## **WRITTEN REPRESENTATION OF MINSMERE LEVELS STAKEHOLDERS GROUP (MLSG)**

### **Minsmere Levels**

### **Representation**

DRAWING TITLE:
MAIN DEVELOPMENT SITE SSSI CROSSING
(UNDER CONSTRUCTION - BAILEY BRIDGE STAGE)

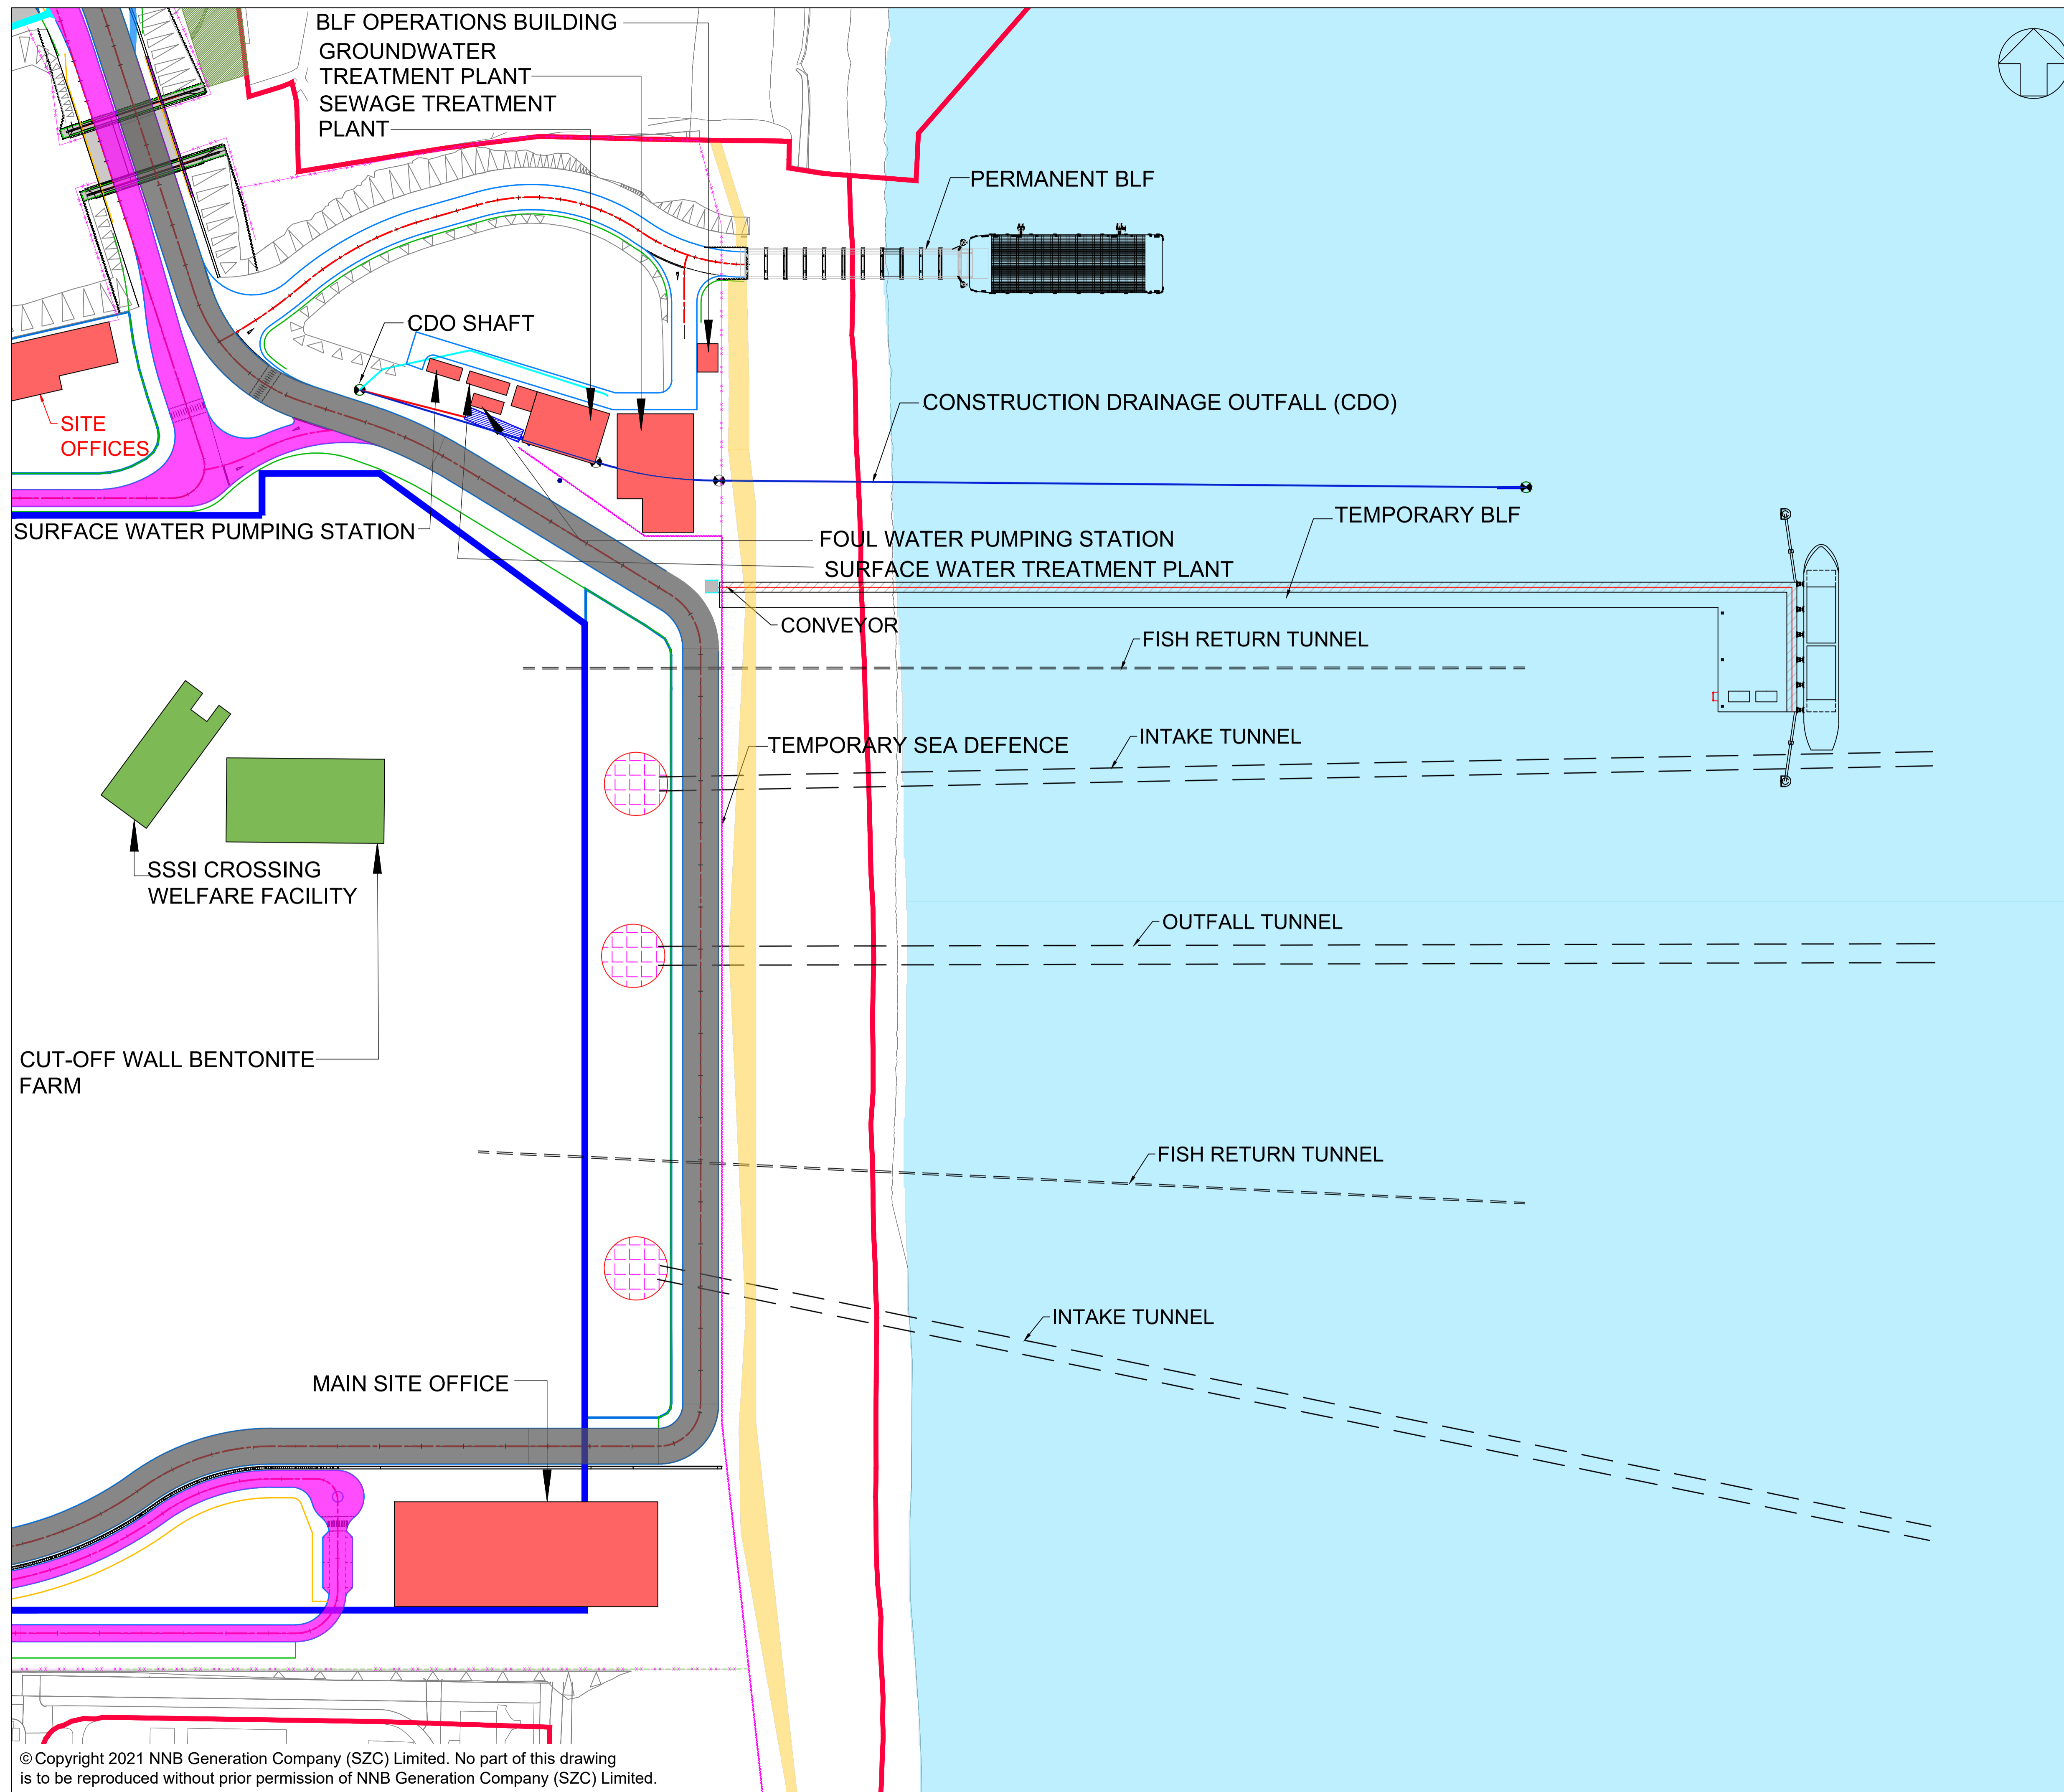
- Hydrological impacts of the proposed Causeway and Culvert crossing are not realistically assessed.
  - The crossing structure is piled within a sheet pile barrier ([PDA-005](#)) which will significantly alter groundwater mobility and restrict natural movement towards the coast, South Minsmere Levels and Minsmere Sluice.
